Our reference: P-900106-Y8P3
Contact: Nick McMaster
Telephone: (02) 4732 8578

19 May 2025

Council Response to Environmental Impact Statement – SSD-70818708 – DHL Logistics Facility Badgerys Creek South at 1953-2109 Elizabeth Drive, Badgerys Creek, NSW, 2555

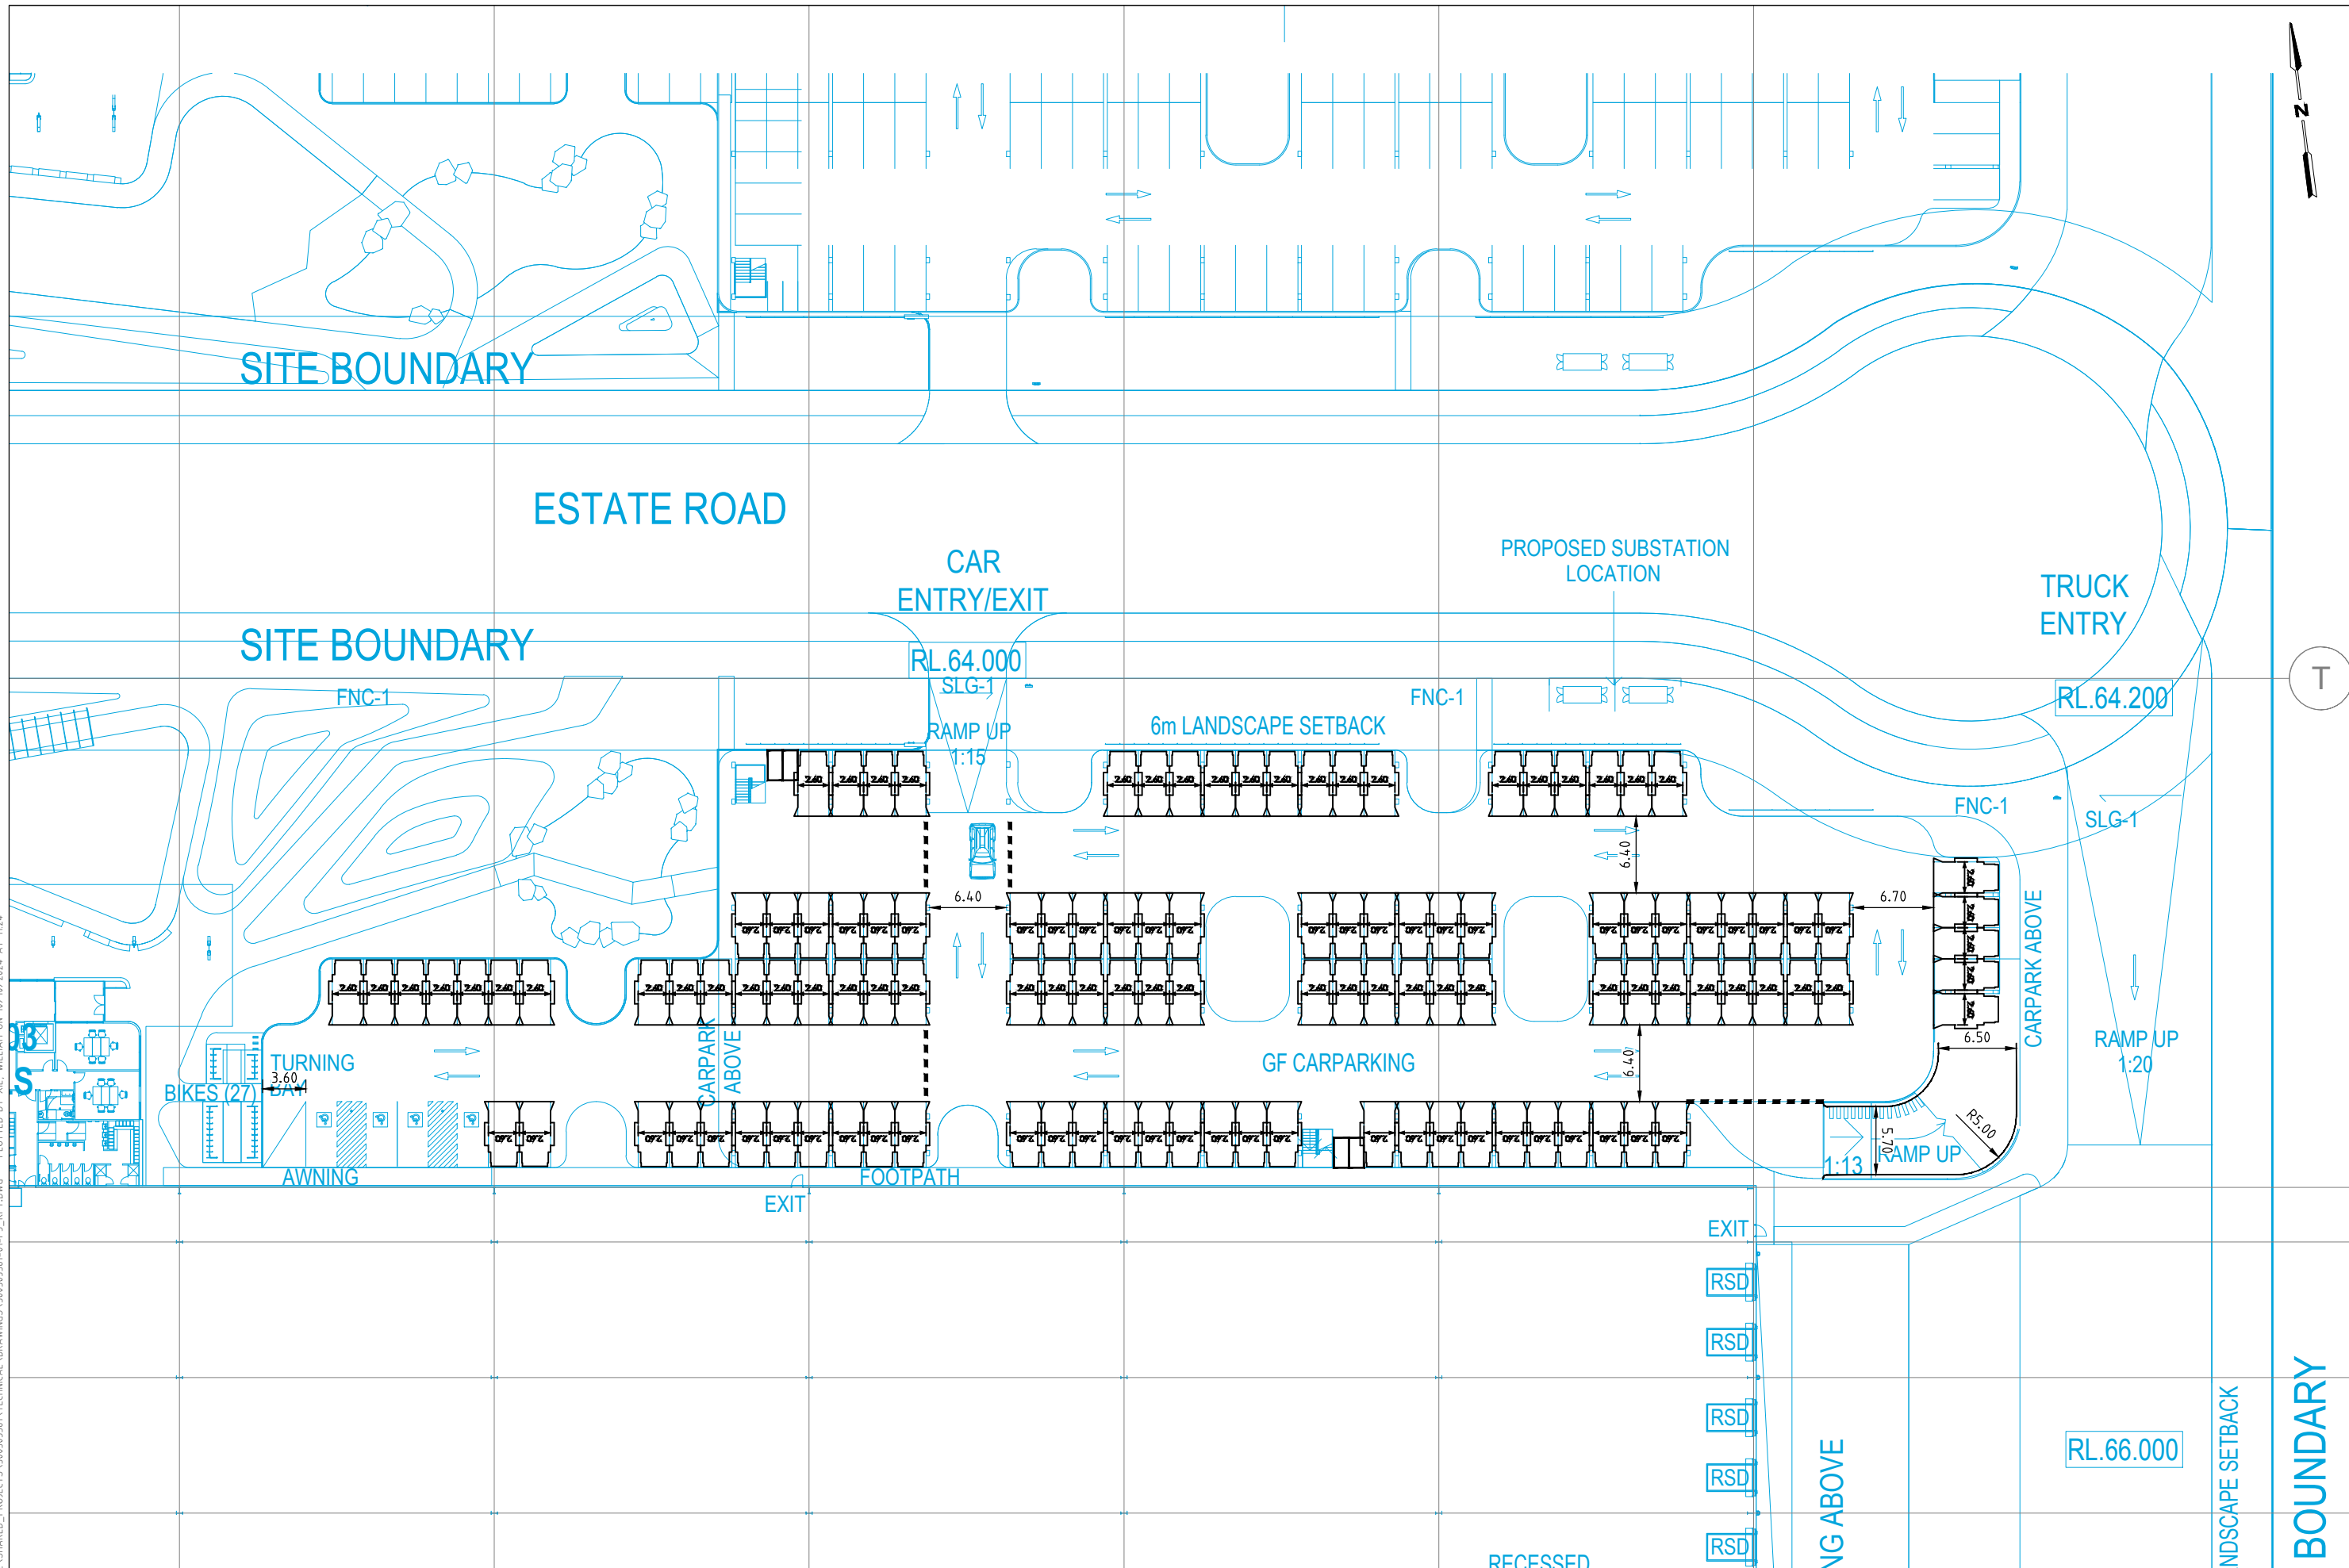
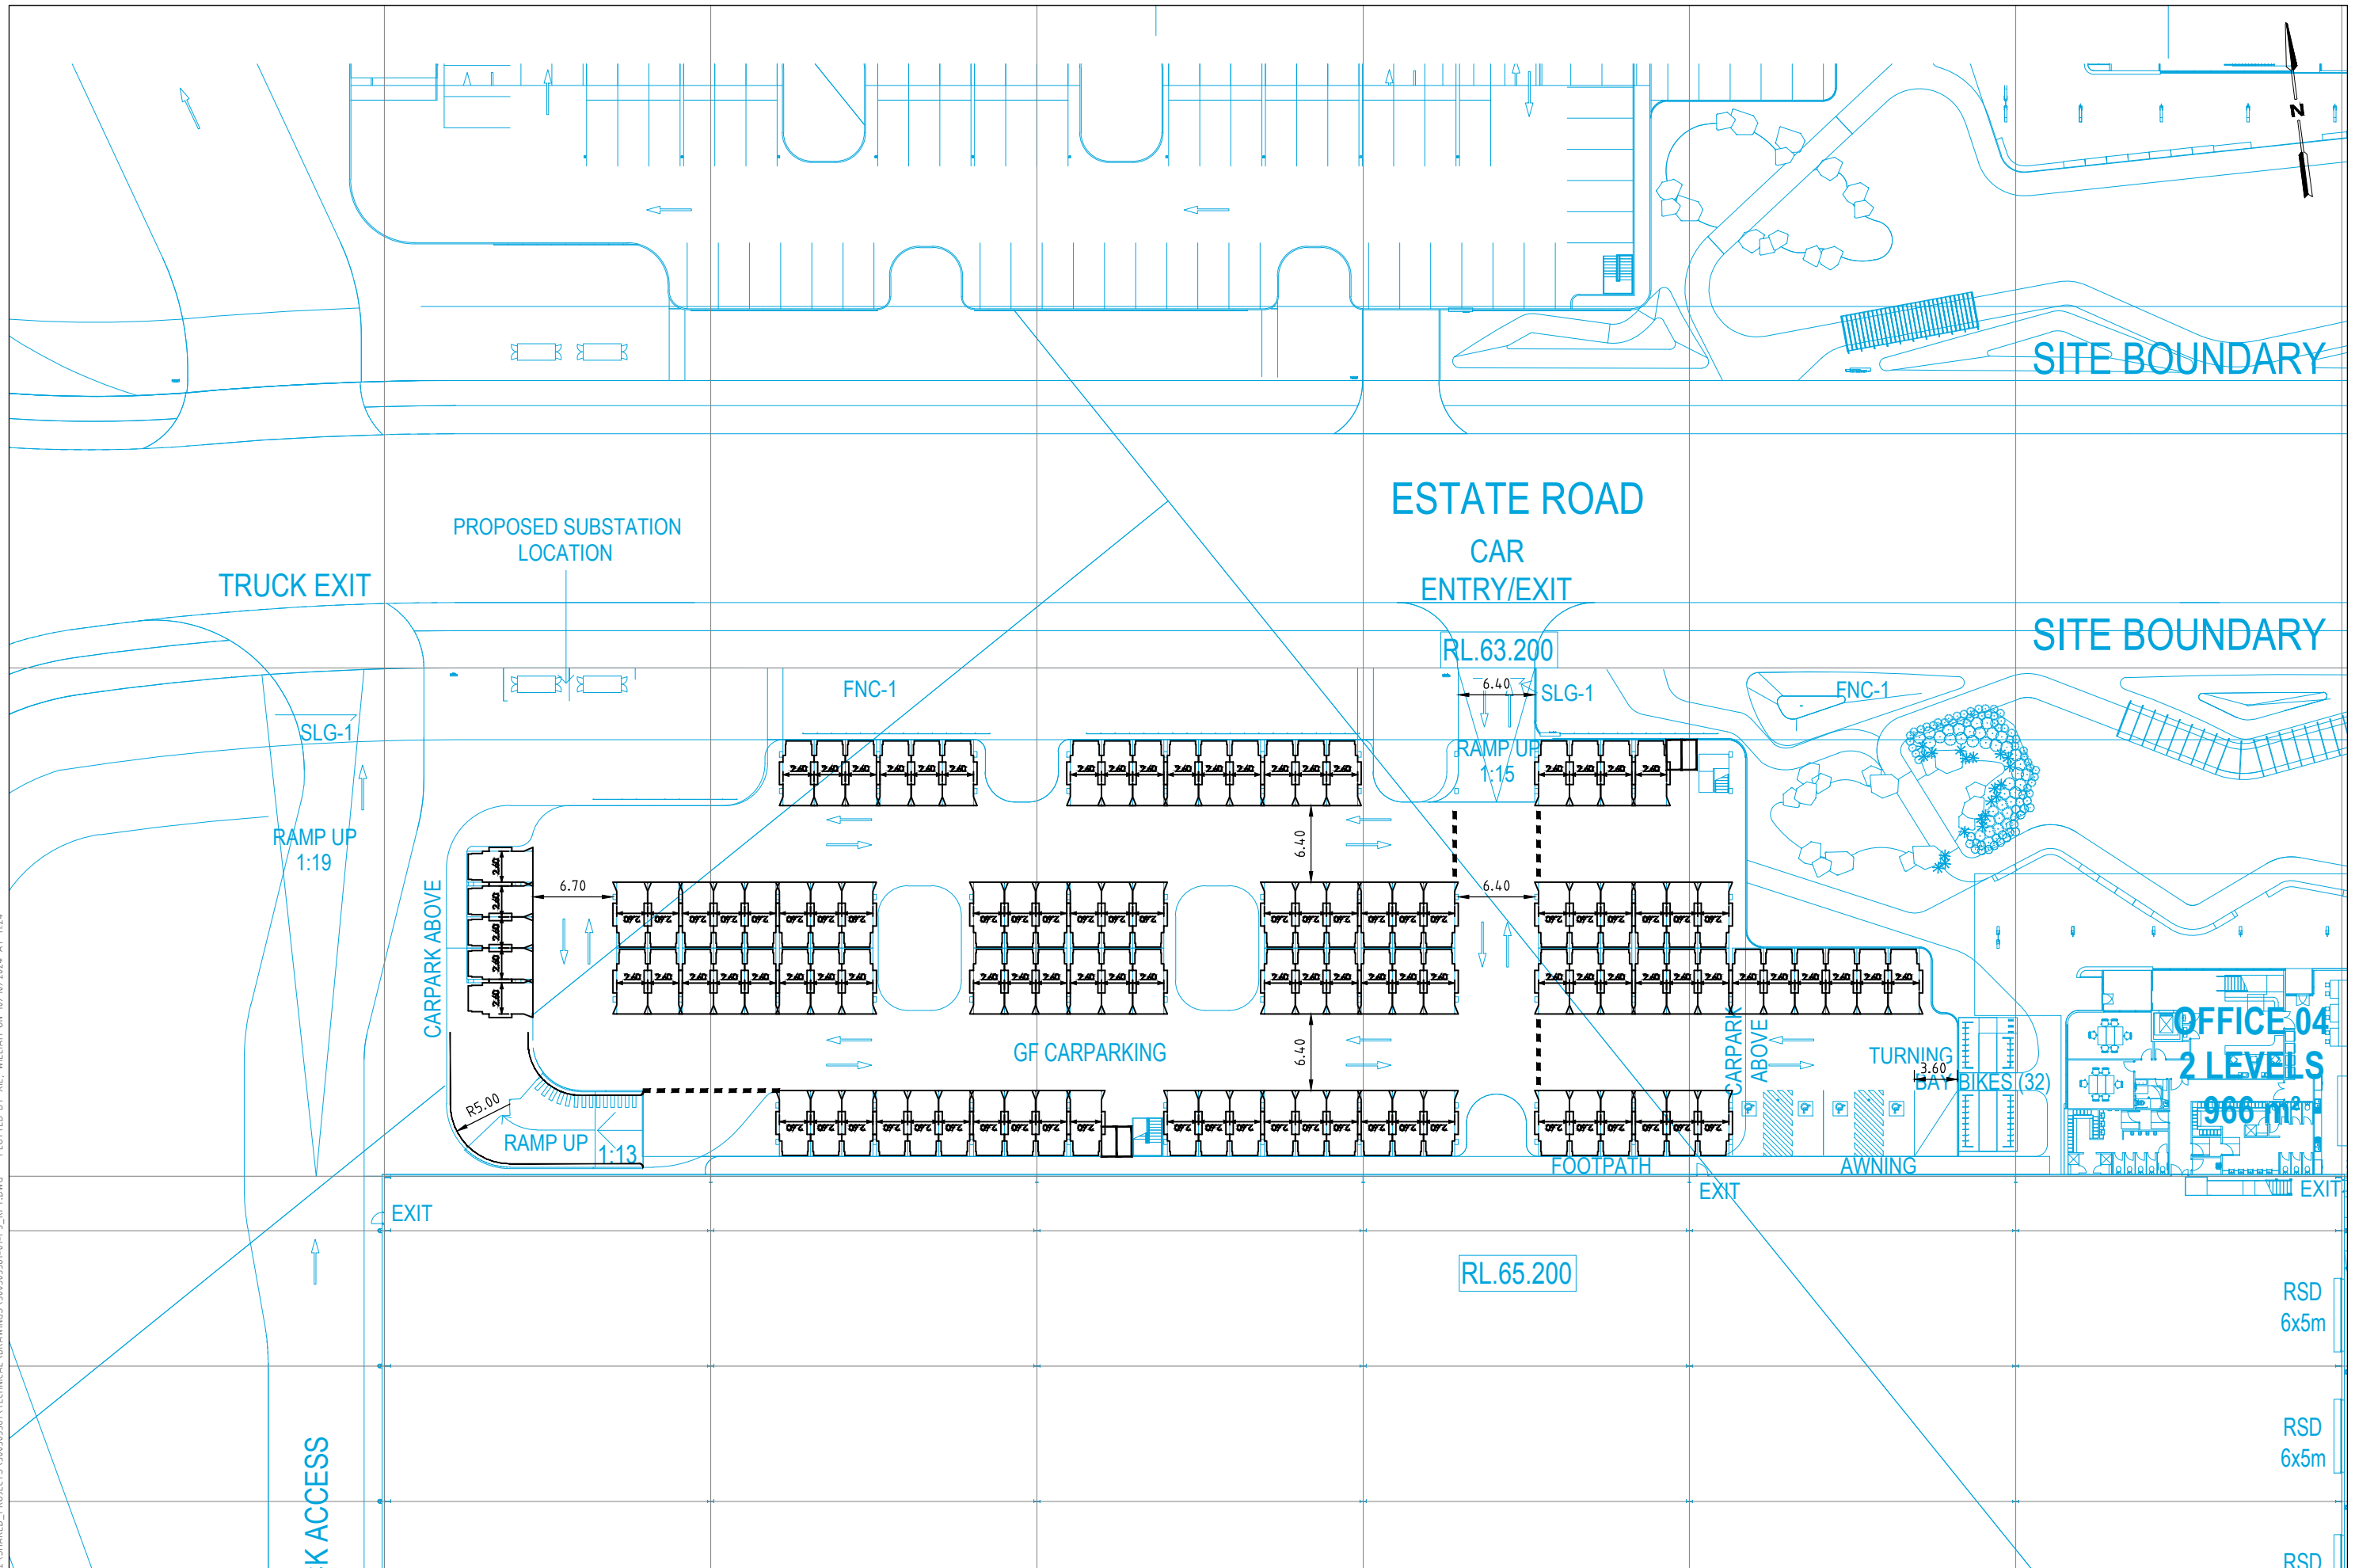
- a) Clarification is required regarding compliance of westernmost proposed truck exit with respect to its proximity to the adjacent intersection. No clear dimensions are given for assessment purposes regarding distance from the intersection.

- b) The architectural plans are not of sufficient detail (dimensions not provided for assessment purposes) to assess whether compliance with AS2890.2 has been demonstrated regarding all proposed truck entry/exit driveways.

- c) The architectural plans are not of sufficient detail (dimensions not provided for assessment purposes) to assess whether compliance with AS2890.1 has been demonstrated regarding car parking areas.

- e) Any internal driveway access gates/boom-gates/etc. must be positioned internally such that a full vehicle length (of the largest vehicle designated to use the corresponding entrance) can be accommodated wholly within the site and not queue on the public roadway. It is not clear from the application whether this has been achieved.
